**From:** [Walker, Daniel](#)  
**To:** [Aquind Interconnector](#)  
**Cc:** [Ford, Jennifer](#); [Szewczyk, Eva](#)  
**Subject:** AQUIND Deadline 2 MMO's response  
**Date:** 20 October 2020 14:34:30  
**Attachments:** [image001.png](#)  
[20201020\\_EN020022-ExA-WOs-DL2-MMO-Response.pdf](#)

Your reference: EN020022  
Our reference:  
DCO/2018/00016

### **The Planning Act 2008, AQUIND Limited, proposed AQUIND Interconnector Project Responses to the Examining Authority's (ExA) First Round of Written Questions**

File name \\UK.WSPGROUP.COM\CENTRAL_DATA\PROJECTS\62100XXX\62100616 - AQUIND VO NO.3\IE MODELS AND DRAWINGS\300 - SITE\340 - TASK 9 MARINE ROUTE\CURRENT\ENVIRONMENTAL STATEMENT\UK\REV 1\FIGURE 3.7 ATLANTIC CABLE CROSSING.DWG.

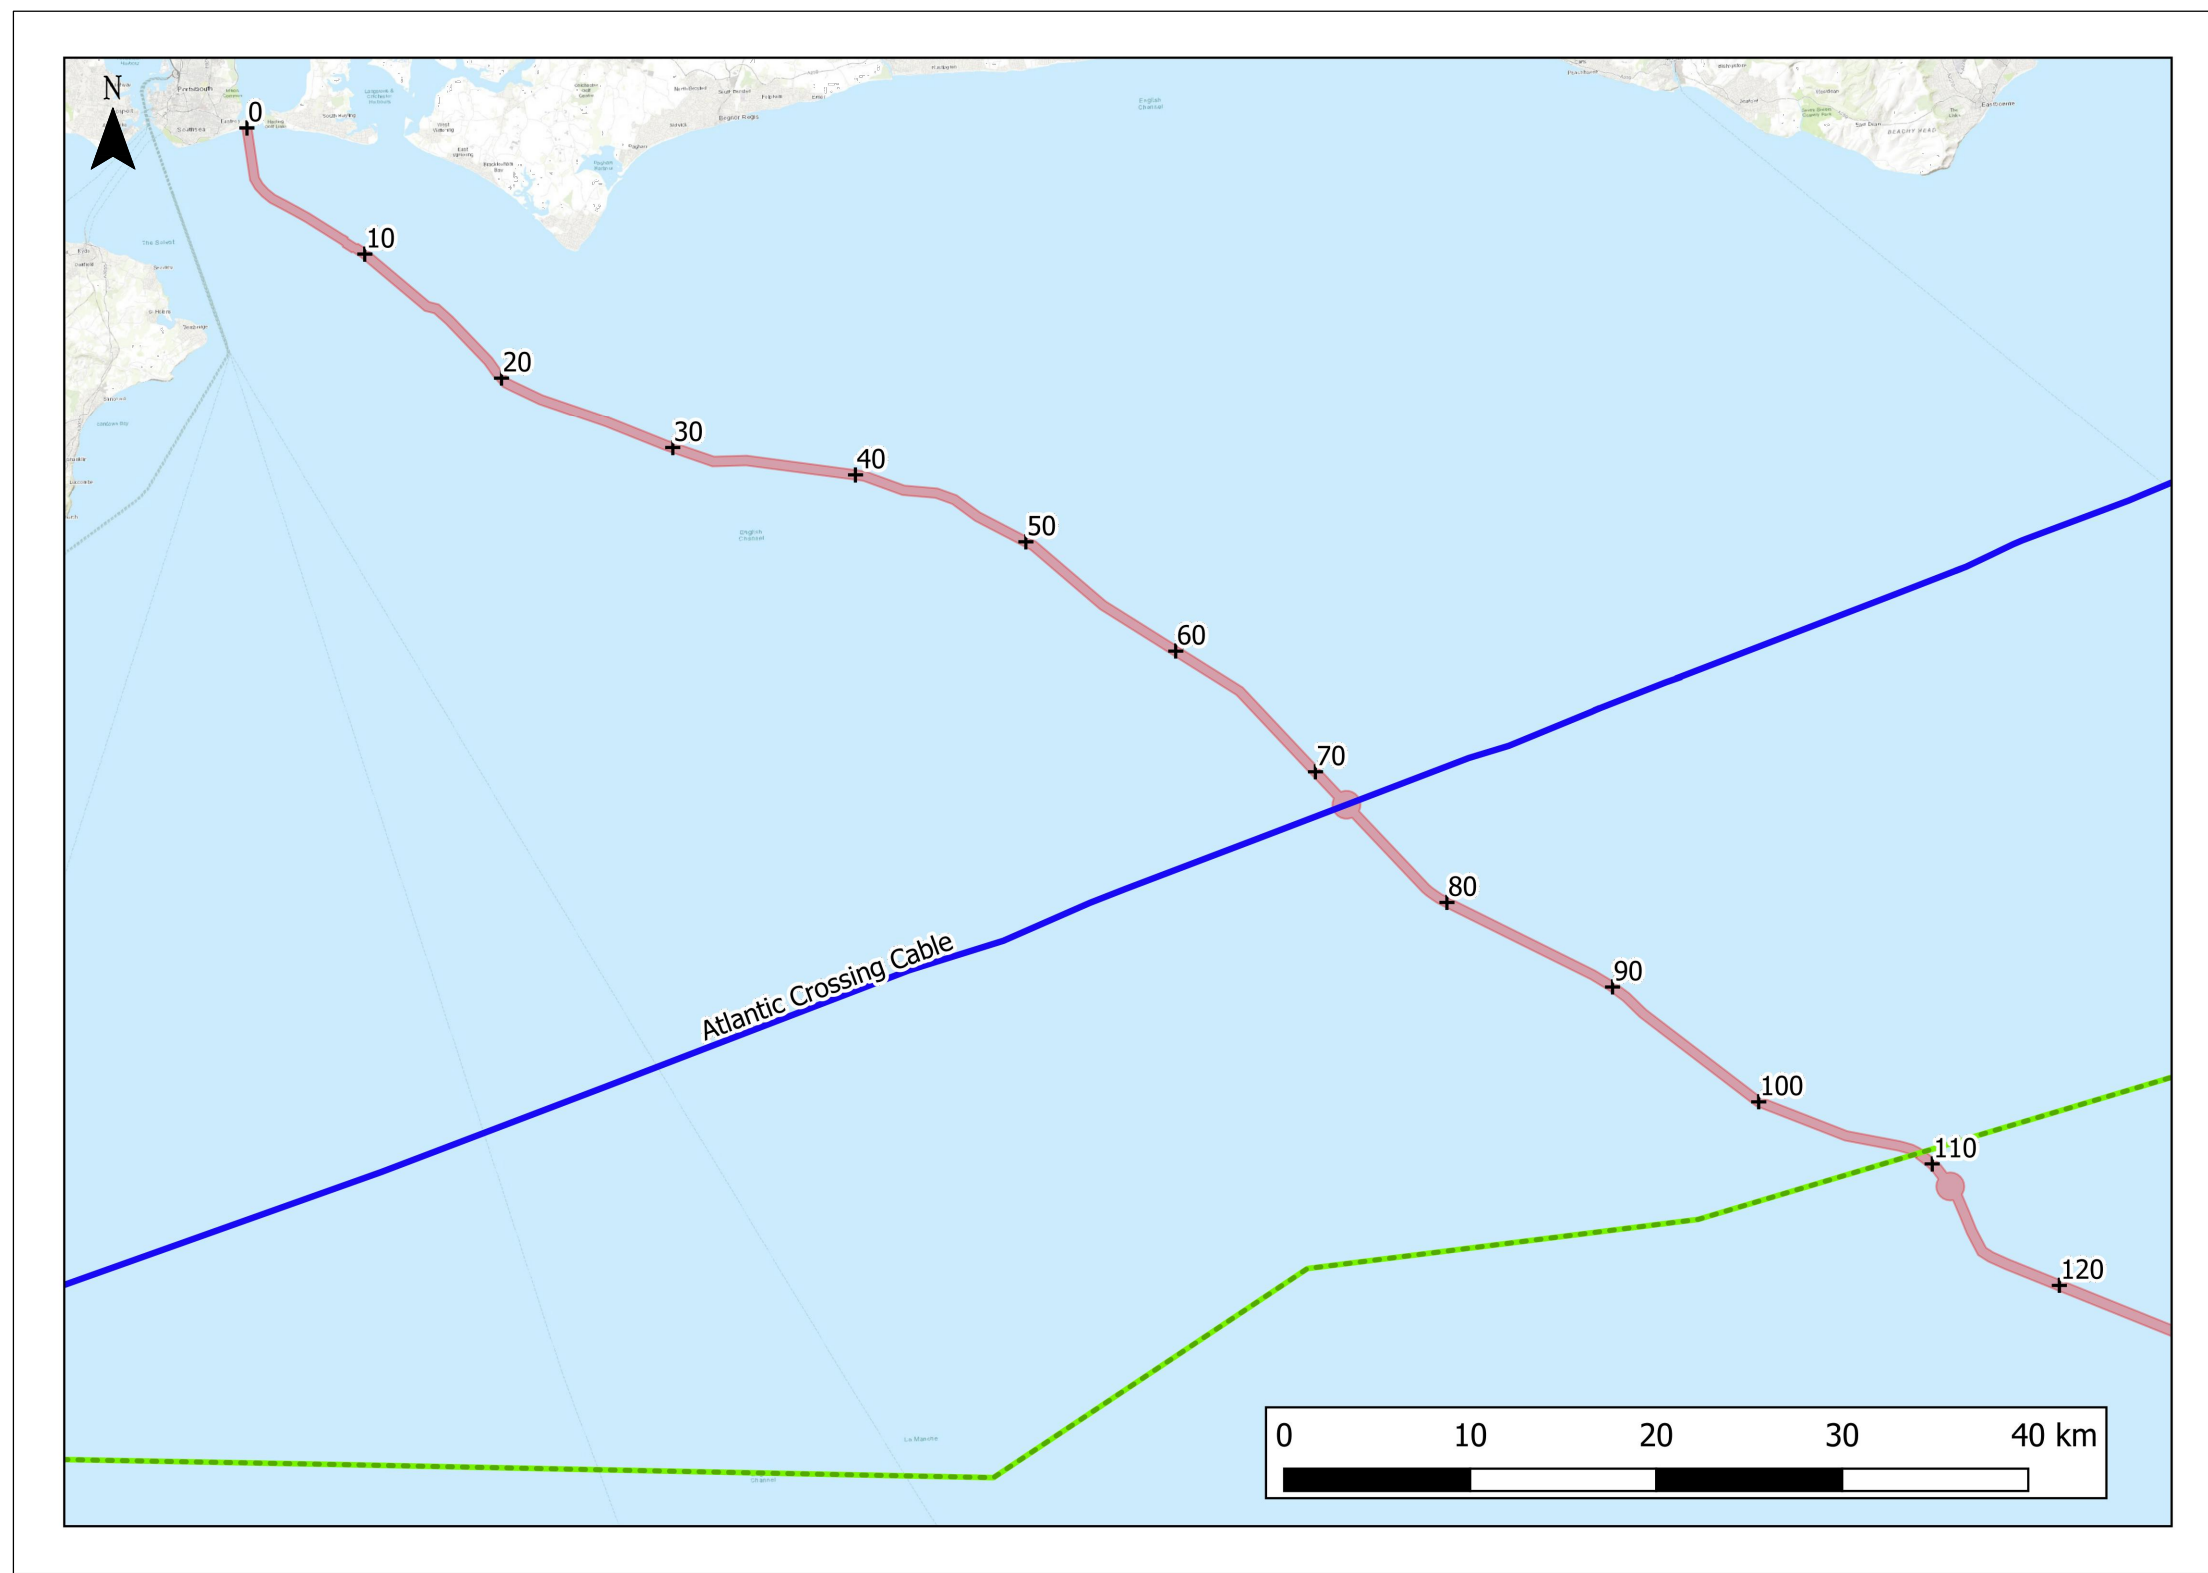
Ref	Question to:	Question:	MMOs position
ME1.10.18	MMO	In relation to paragraph 6.6.4.10 of the ES [APP-121], Schedule 15 Part 2 of the dDCO (the DML) [APP-019] and the Atlantic cable crossing protection, are the parameters assessed appropriate and can reliance be placed on the Applicant's assessment of significance?	<p>The applicant has deemed the potential impact of the Atlantic Crossing Protection to be of medium magnitude and thus of minor to moderate significance. This remains unchanged since the applicant initially submitted the ES and MMO agreed with the assessment presented relating to this component of the project. Therefore, reliance can be placed on the applicant's assessment of significance.</p> <p>However, through consulting the MMO's technical advisors, the following point has been raised. Schedule 15 Part 2 Paragraph 11, sub-paragraph (1) of the draft DCO lists several items ((a) through (d)) which the Cable burial management plan should include. As the significance of effects to the seabed resulting from the Atlantic Crossing protection has been assessed as having minor to moderate significance, MMO requires that this plan also include an</p>

<p>assessment of changes to the seabed around cable protection (including scour and erosion and alteration to bed forms). This should include (but not necessarily be limited to) monitoring of the effects resulting from Atlantic crossing protection. MMO considers this appropriate because scour and erosion occurring around cable protection may influence the measures which need to be implemented as part of the cable burial management plan, and therefore this evidence should be presented to support and justify the contents of the plan.</p> <p>The table under Schedule 15 Part 2 paragraph 1 of the draft DCO defines the maximum total allowable length and area of the cable protection but does not specify the Atlantic Crossing Protection separately. If the dimensions of the Atlantic Crossing Protection exceed (in width or height above the bed) those defined for other cable protection, the MMO recommend that this 600 m length of cable protection is defined separately, and the dimensions are specified.</p>
